## Comments on Planning Applications 2021/1089 and 2021/1090

Many of the documents are the same, if with different filenames. Comments are common to both if appropriate.

TTE Project Number	Drawn By	Date	Checked By	Date	Approved By	Date	Scale @ A1	Subality
B028734	NR	Jun '21	GM	Jun '21	EJ	Jun '21	1:500	S3
Client Project Number	Originator	Volume/System	Level/Location	Type/Code	Role	Number	Revision	
PRJ01	- TTE	- 00	- ZZ	- DR	- S	- TPP17	P01

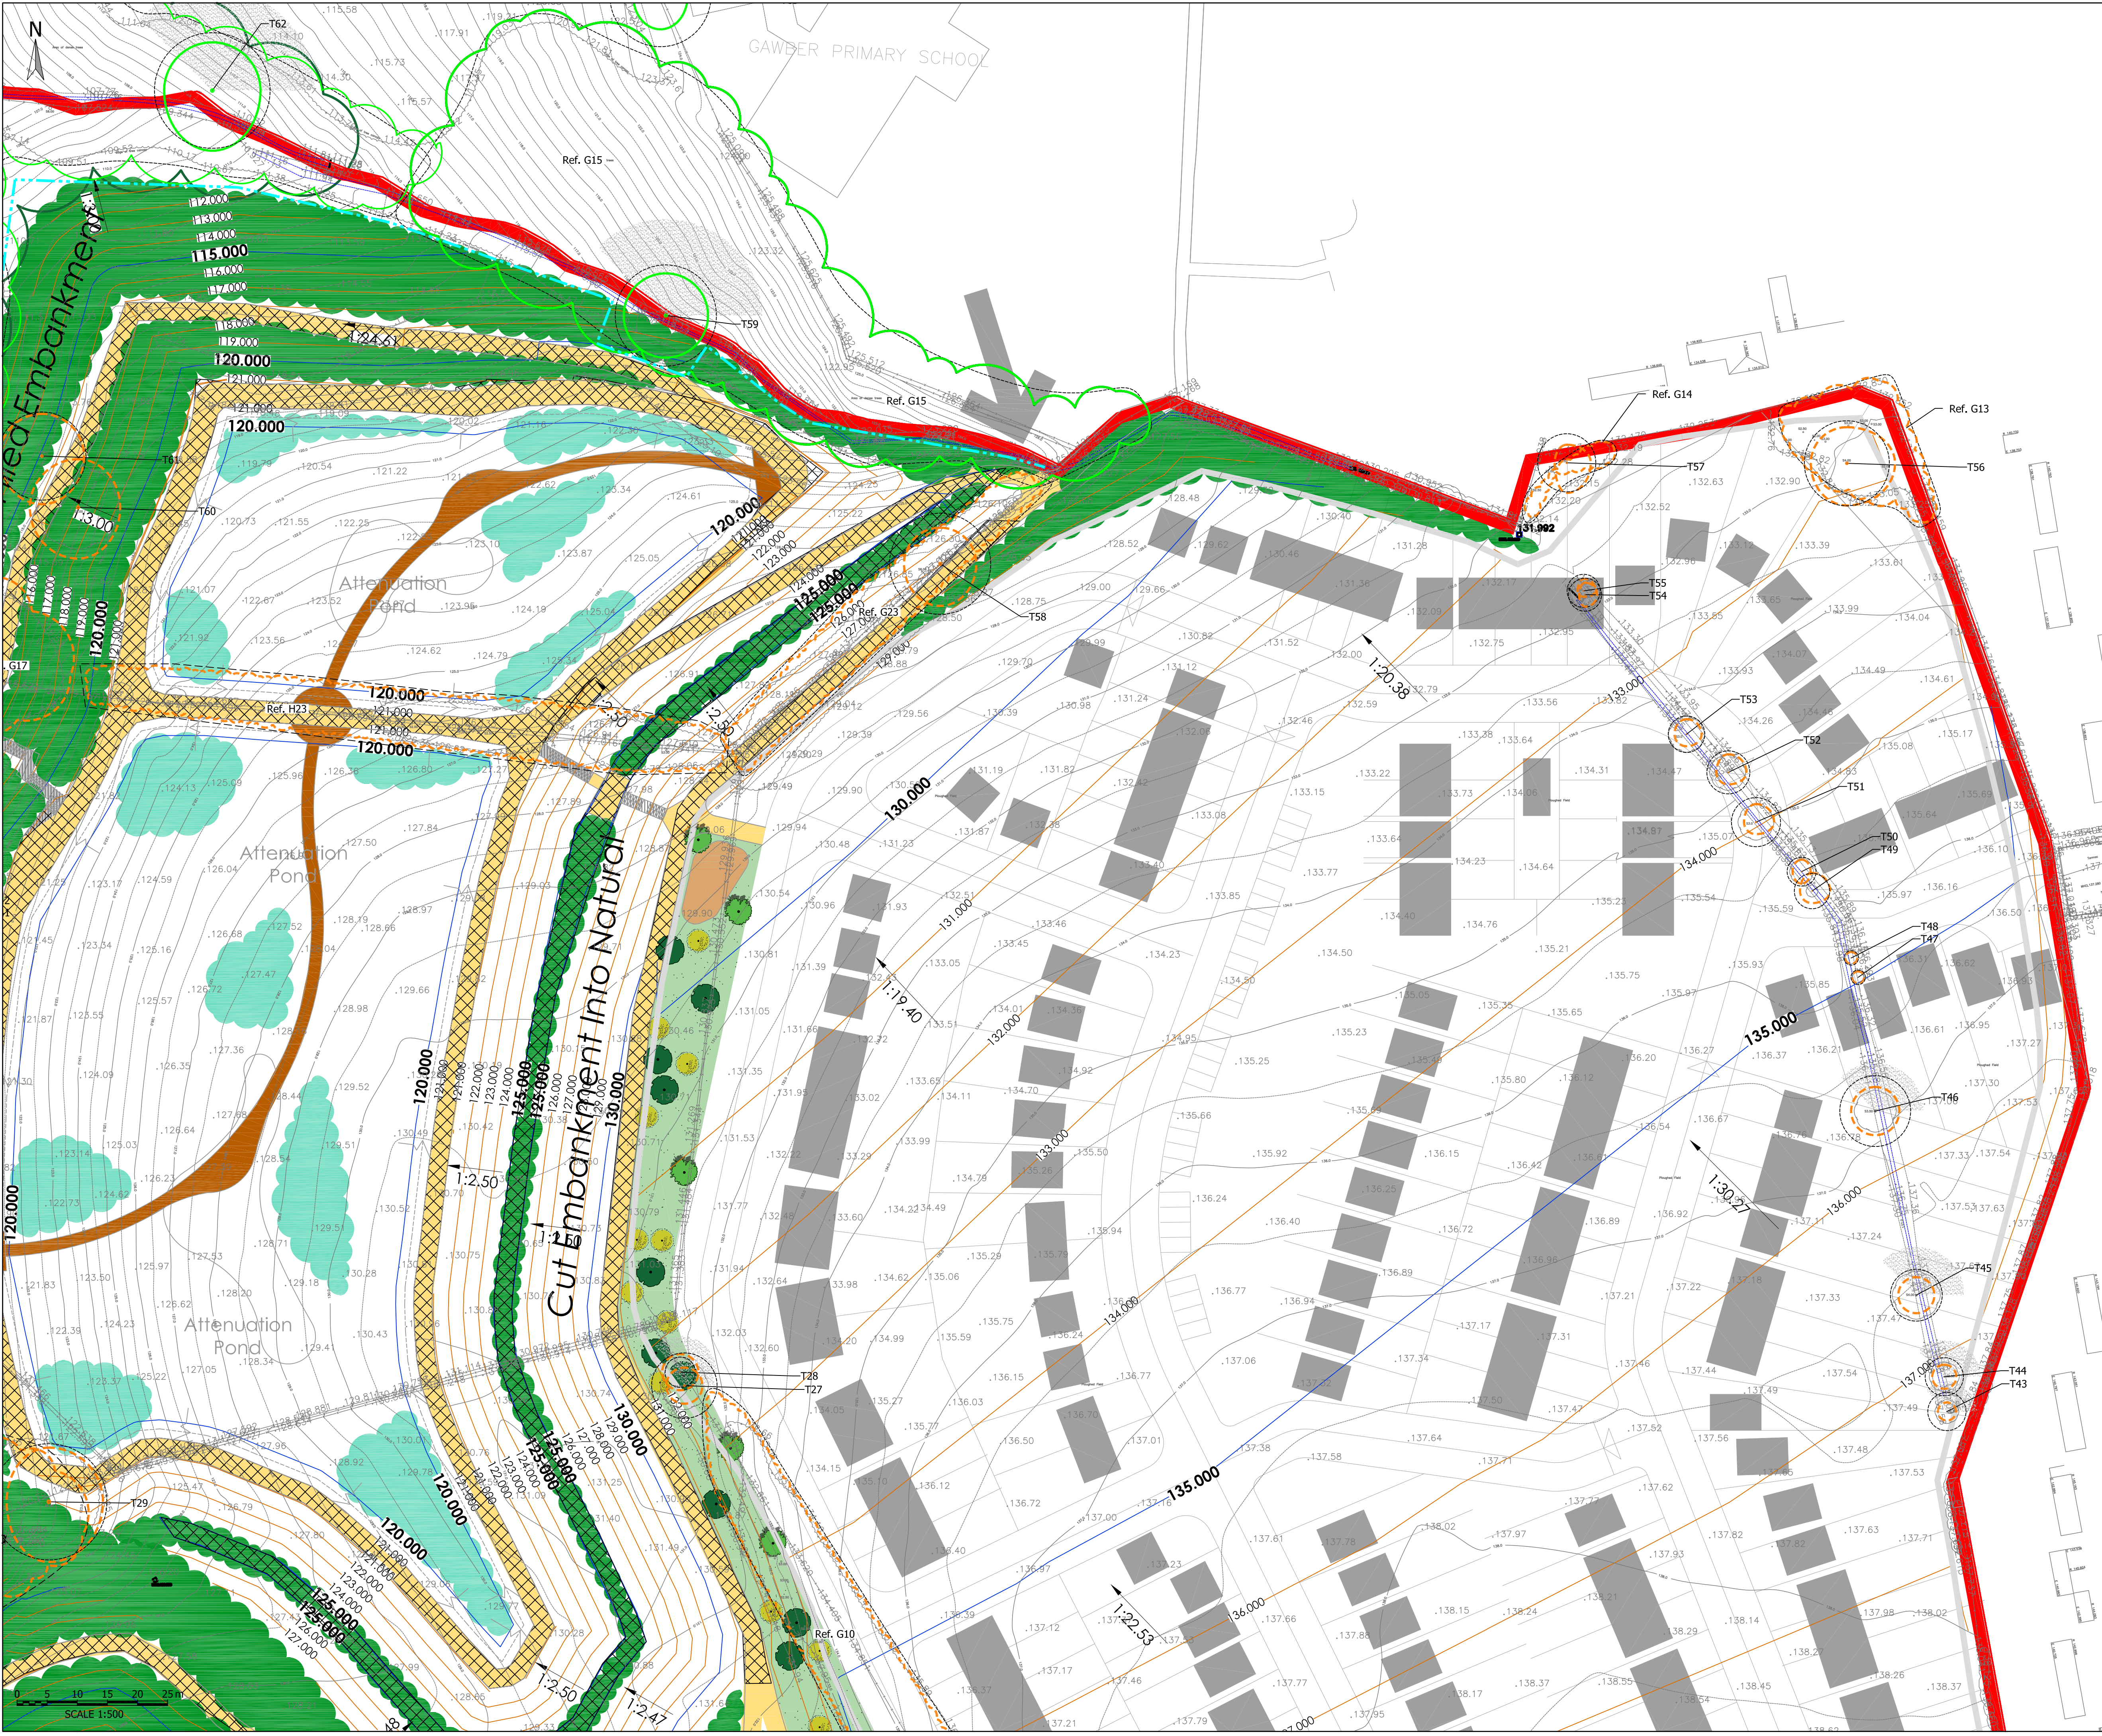
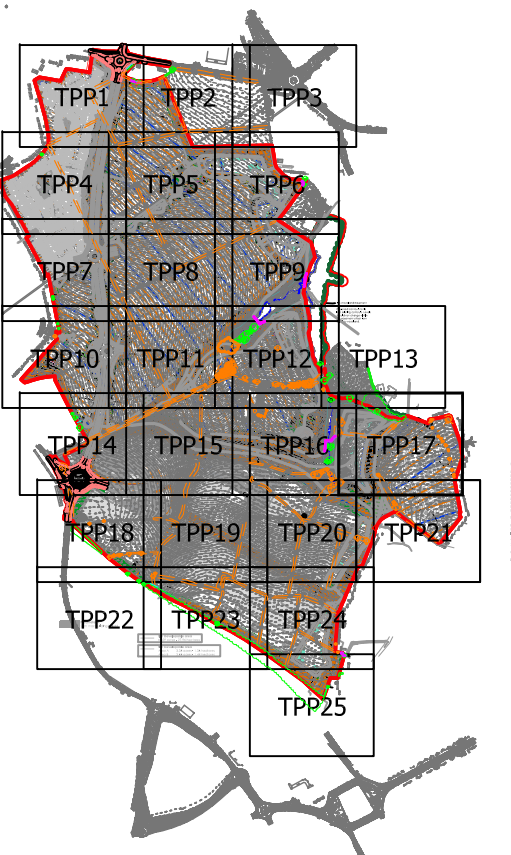
Trees in the corner of Wharfedale Rd/Colster Close are classed as trees of moderate quality with a 20 life span and some of them at least were planted as part of a planning consent, but all appear to have been slated for removal. Is this correct? If so, why?
